Cleve Hill Solar Park

DCO Application Reference EN010085

Answers to the Examination Authority's written questions and requests for information
(ExQ1) from

Kent Wildlife Trust

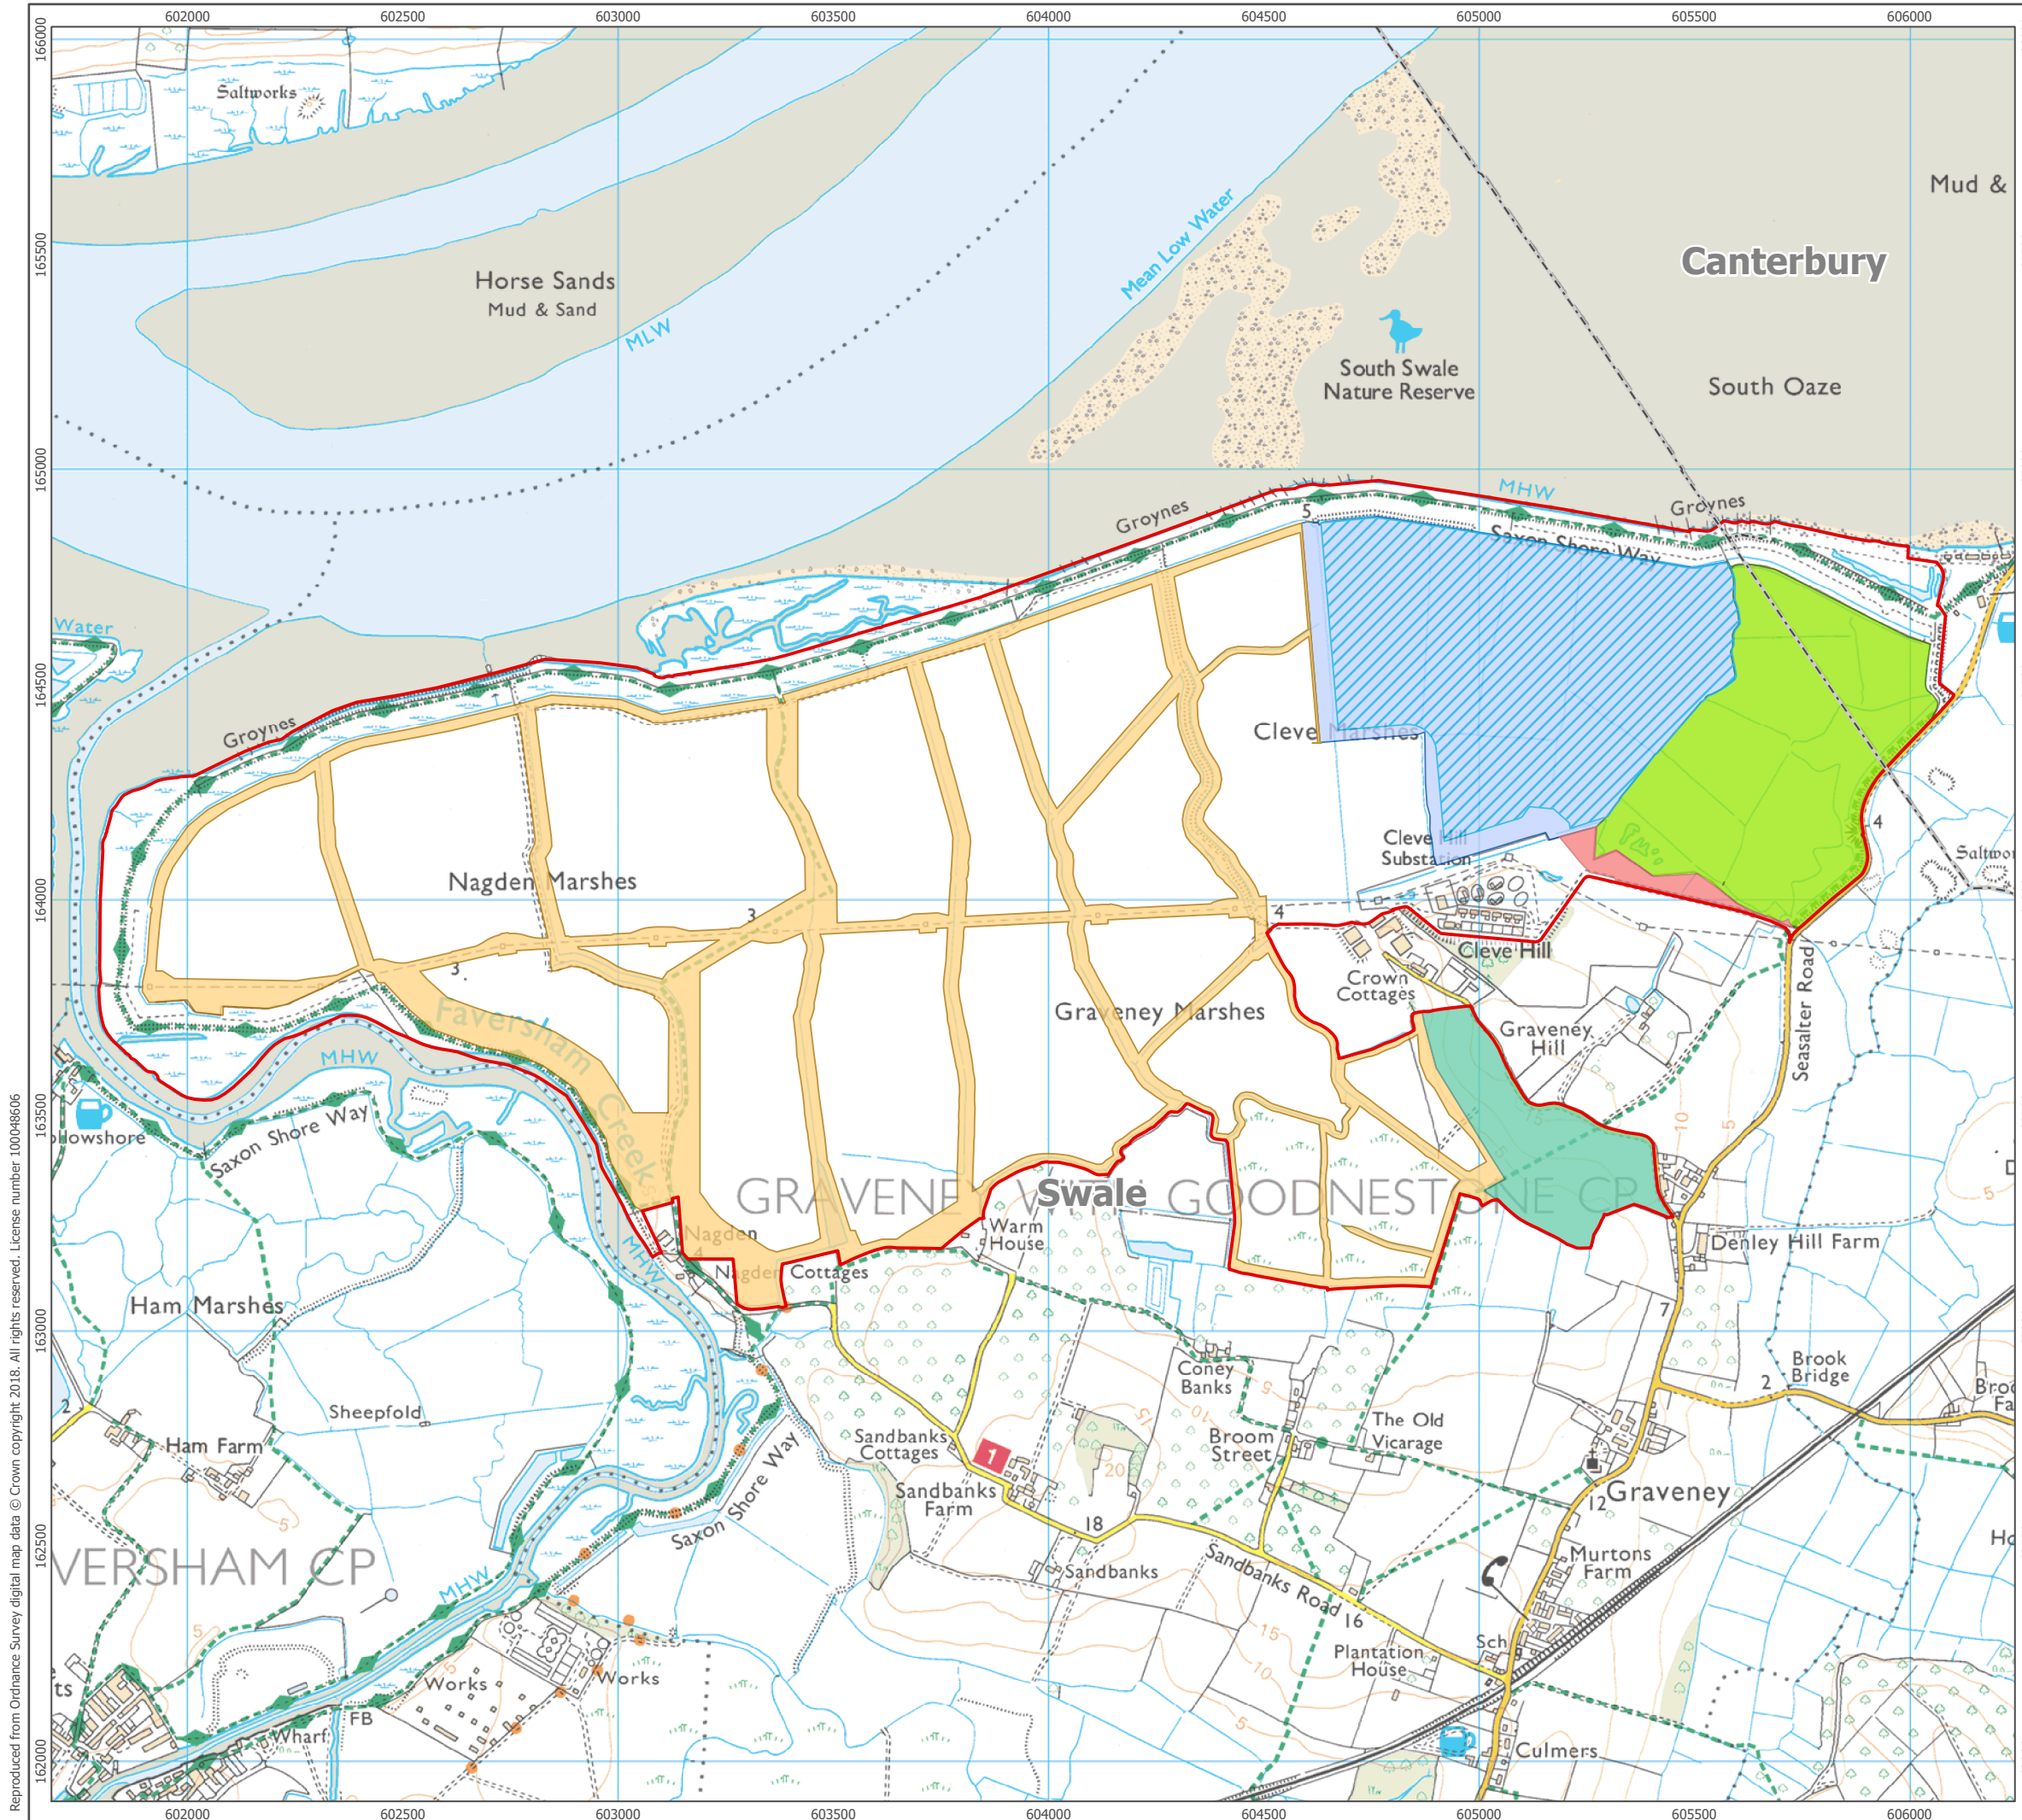
In particular, we would like to know how the Applicant proposes to control grazing densities within the perimeter fencing. At present, the LBMP treats the area within the perimeter fences as single compartments, but as can be seen from Habitat Management Areas figure (Figure 9.3 within APP-056) these areas can be divided into the ditches and buffers that are proposed to mitigate impacts on marsh harriers, and grassland under solar panels. It can be expected that outcomes between these two areas for any given grazing density (for the combined area) will be different, owing to the different growing conditions between them and behaviour of grazing stock. Another consideration is the prevention of poaching of ditch banks. We therefore consider it necessary to be able to control the grazing density between these areas separately. The provisions for grazing within the LBMP also need to be robust enough to avoid being compromised by commercial grazing interests.
